MORGAN AND MORECAMBE OFFSHORE WIND FARMS: TRANSMISSION ASSETS

Response to Section 51 advice

December 2024

Document reference: S_S51_1

**Drawing Number:**  
BP-GBR-MORG-REG-0181

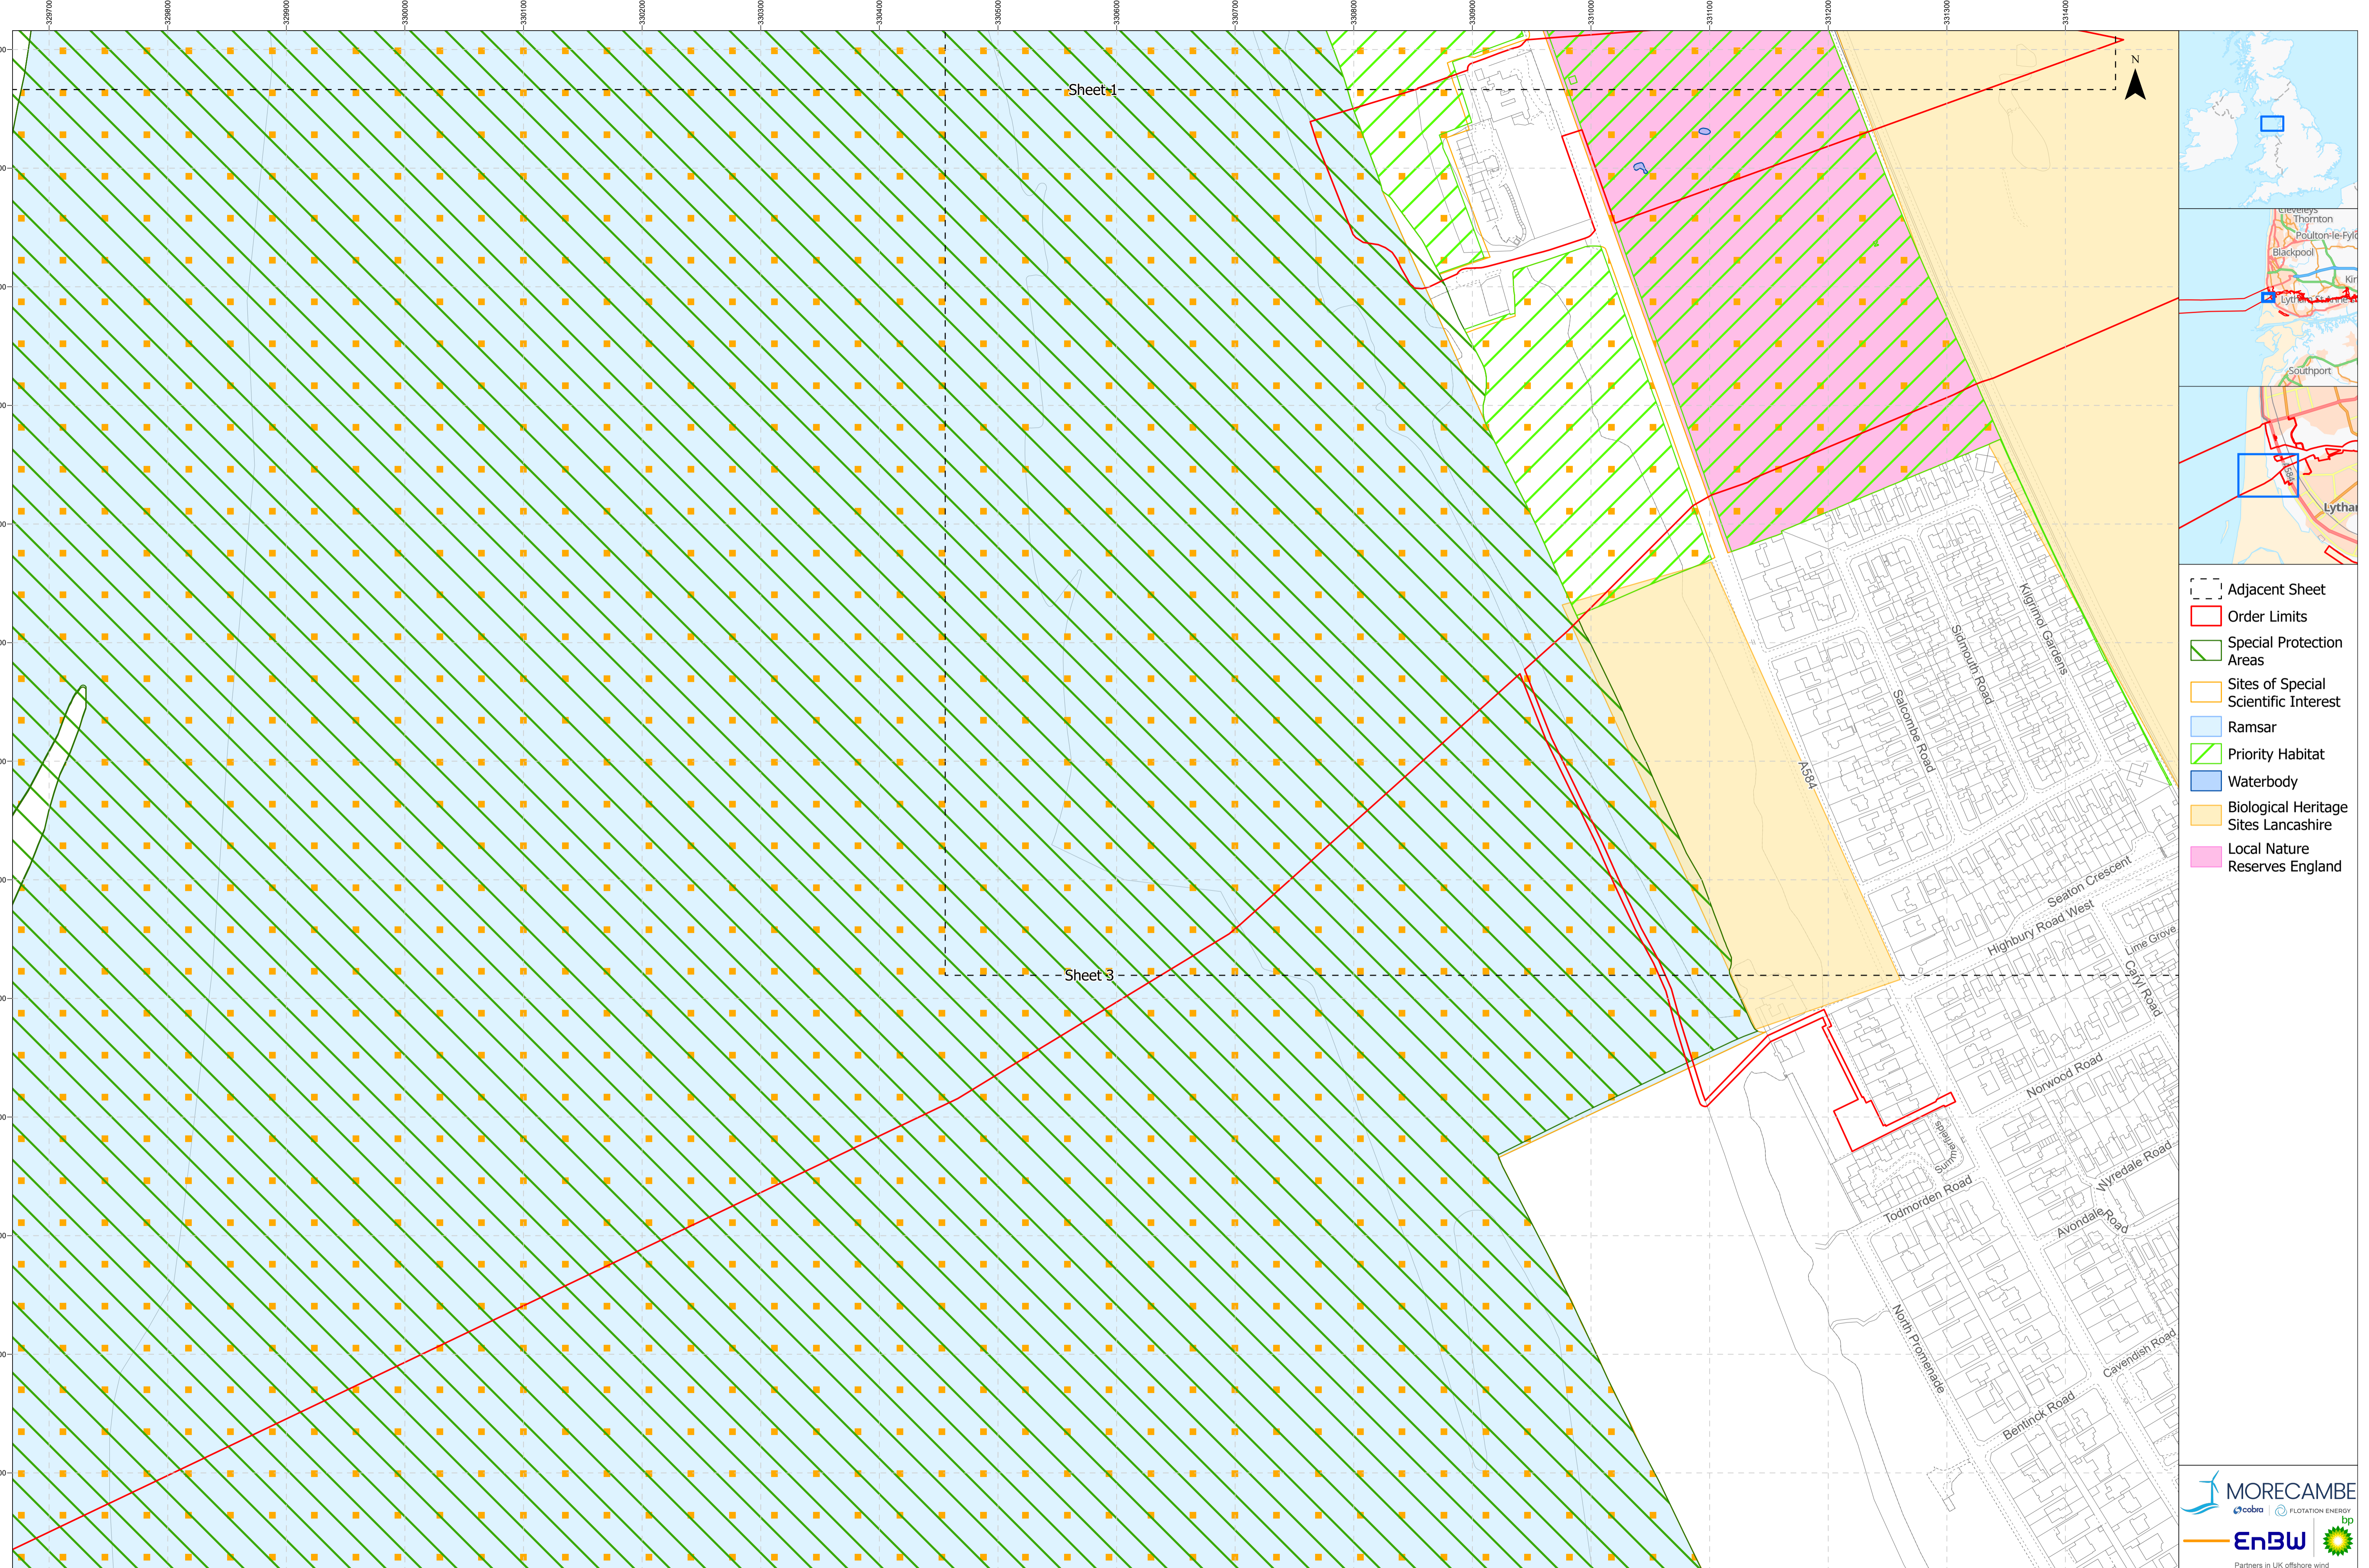
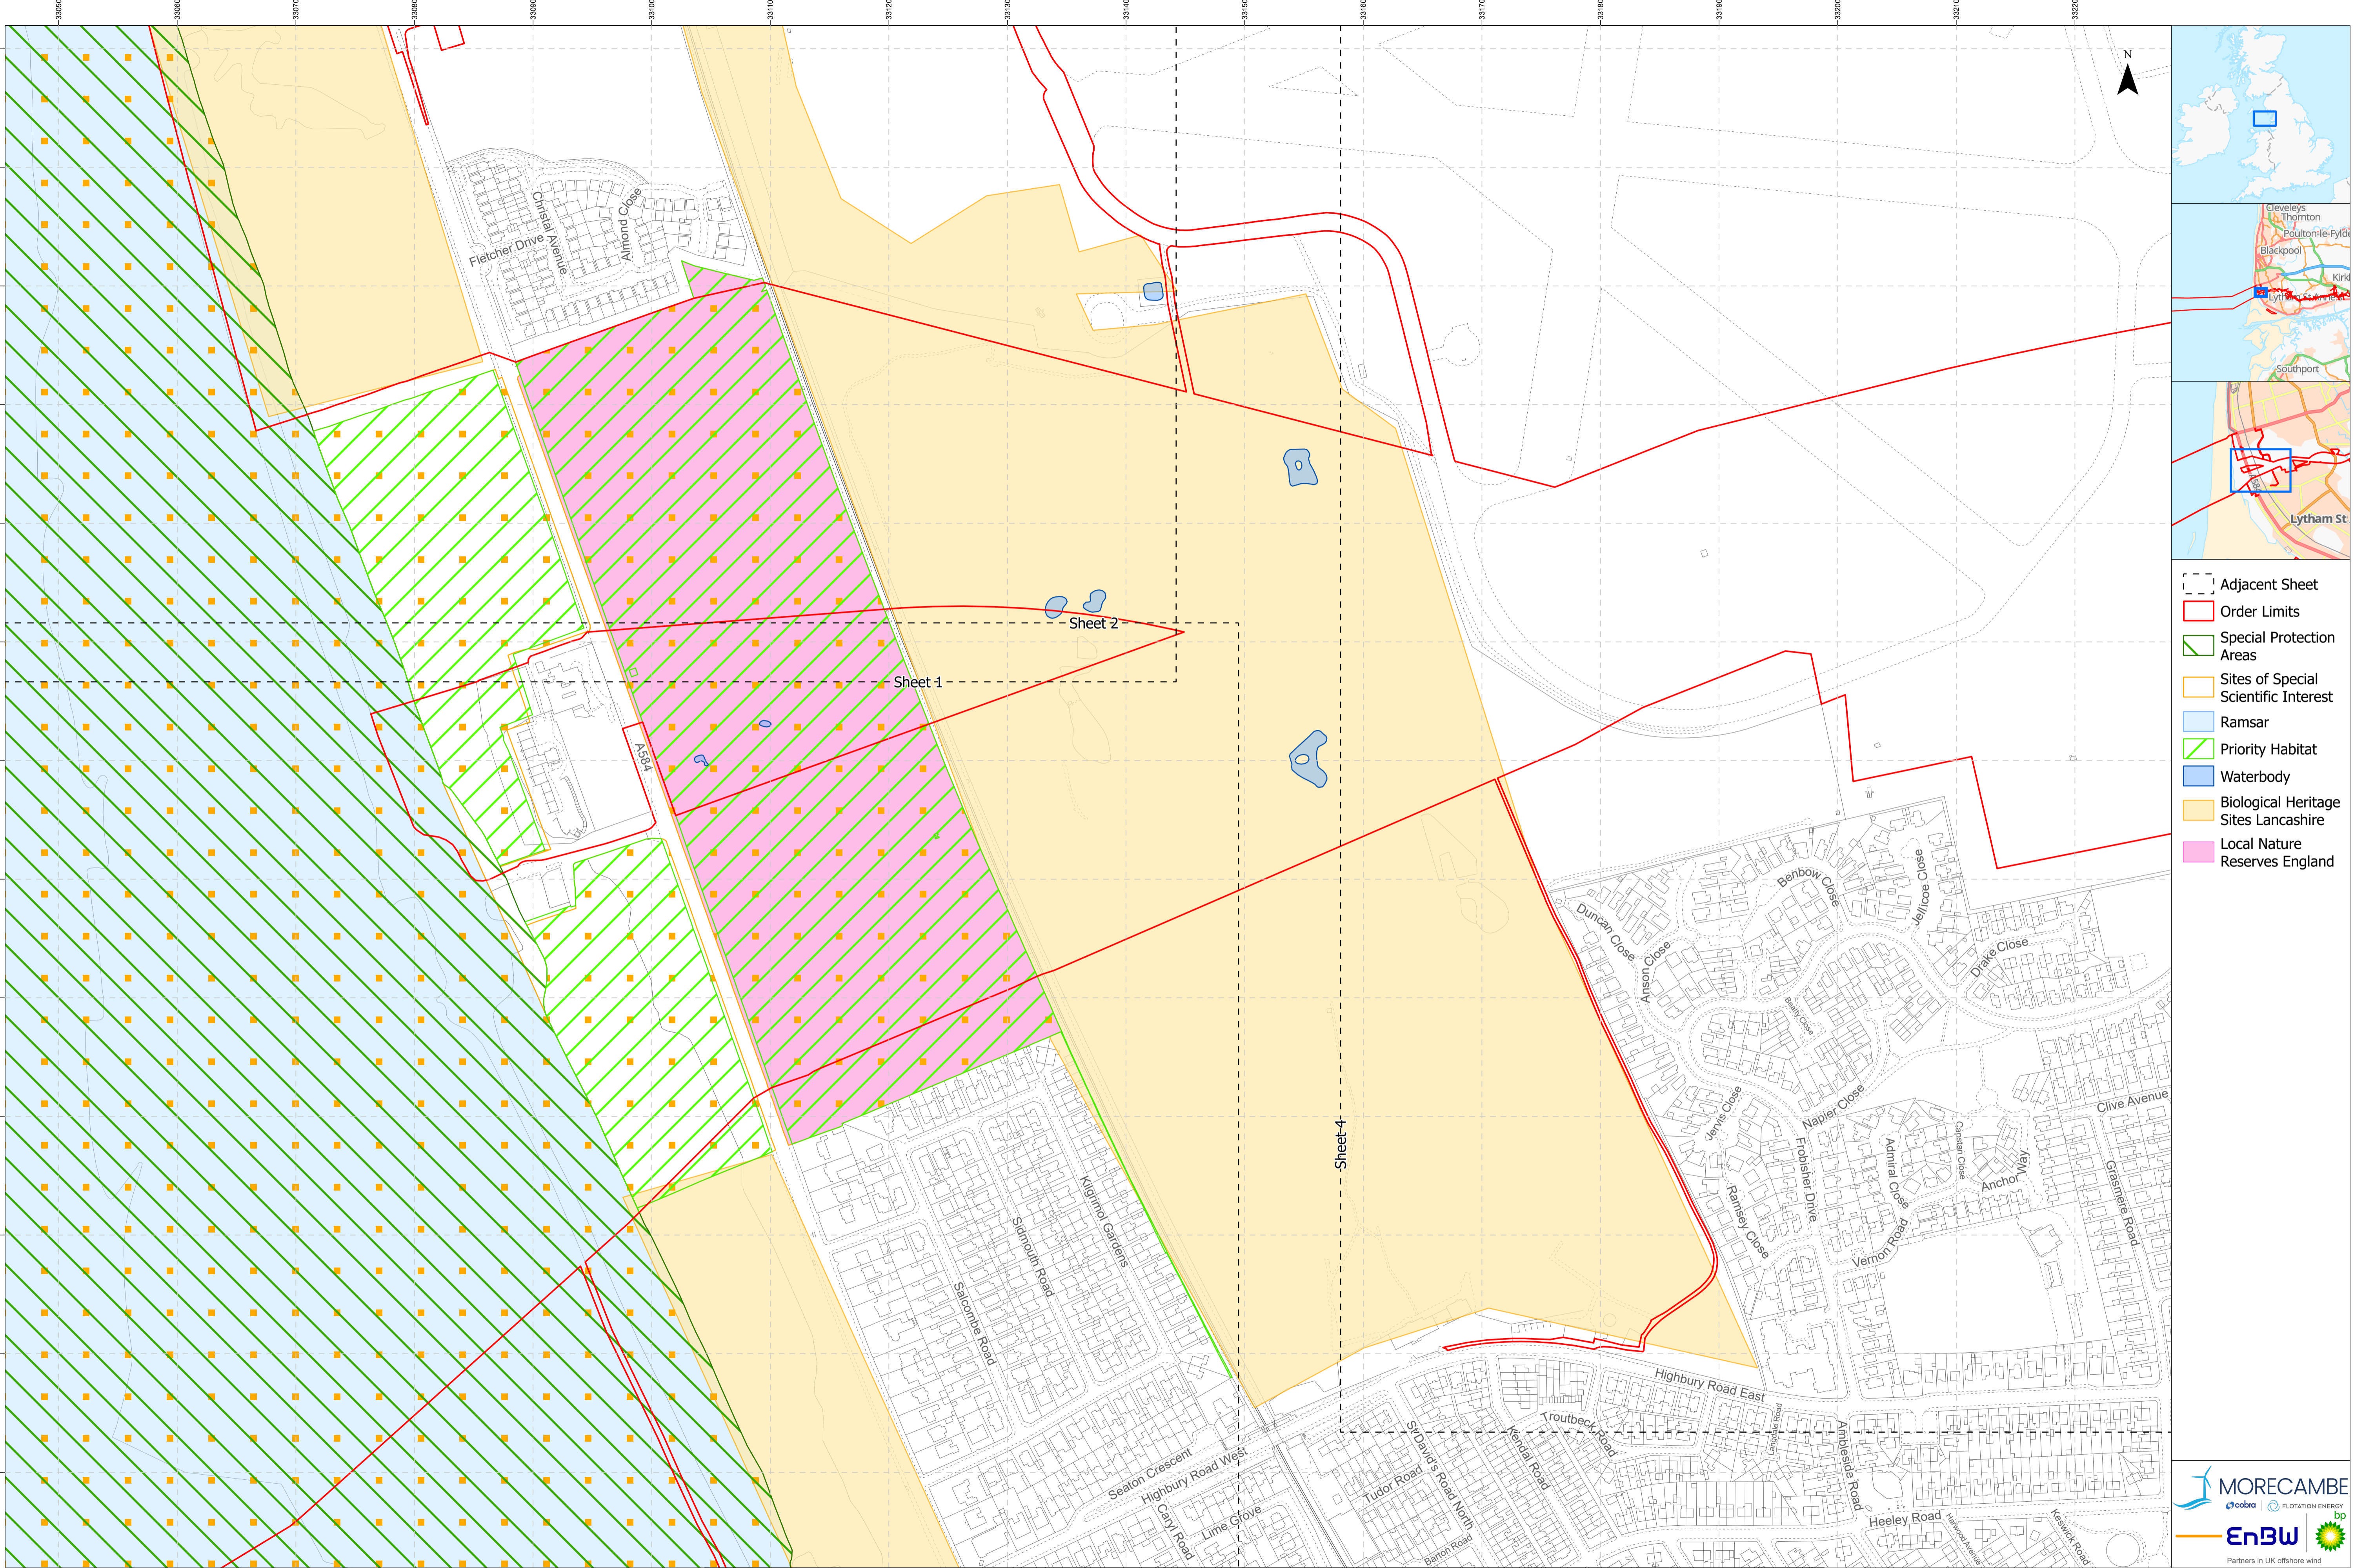
Onshore Statutory and Non-Statutory Nature Sites and Onshore Historic or Scheduled Monument Sites	<p>“The plans showing Onshore Statutory and Non-Statutory Nature Sites (and Waterbodies in a River Basin Management Plan) (Doc B14) and Onshore Historic or Scheduled Monument Sites (Doc B16) present the sites, rivers or historic assets, however these are not labelled (unlike the equivalent offshore plans). The Applicants are advised to provide an updated set of figures with appropriate labelling of the features being represented. “</p>	<p>The Applicants have updated this document with the requested changes and have submitted it to the Planning Inspectorate (document reference: B14/F02 and B16/F02). Both documents contain a Schedule of Changes.</p>
Onshore Historic or Scheduled Monument Sites	<p>Between the onshore historic or scheduled monument sites (Doc B16) and ES Volume 3 (Doc F3.12, figures for chapter 5), there appear to be some minor differences in terms of the specific assets recorded between these drawings. An example is Doc F3.12 ES figure 5.7 compared to sheet 3 of Doc B16. The Applicants are advised to provide an updated set of figures which are consistent in the features being represented, with appropriate labelling.</p>	<p>The Applicants have reviewed the Onshore Historic or Scheduled Monument Sites plan alongside the Environmental Statement (ES) Volume 3 Figures and can confirm that the data included is the same. However, the data shown on the ES figures has been separated based on the time period for the records. To facilitate ease of cross-referencing between the documents, labels referencing the heritage asset list entry have been added to the Onshore Historic or Scheduled Monument Sites plan (document reference: B16/F02). The Applicants have submitted the updated Onshore Historic or Scheduled Monument Sites plan (document</p>
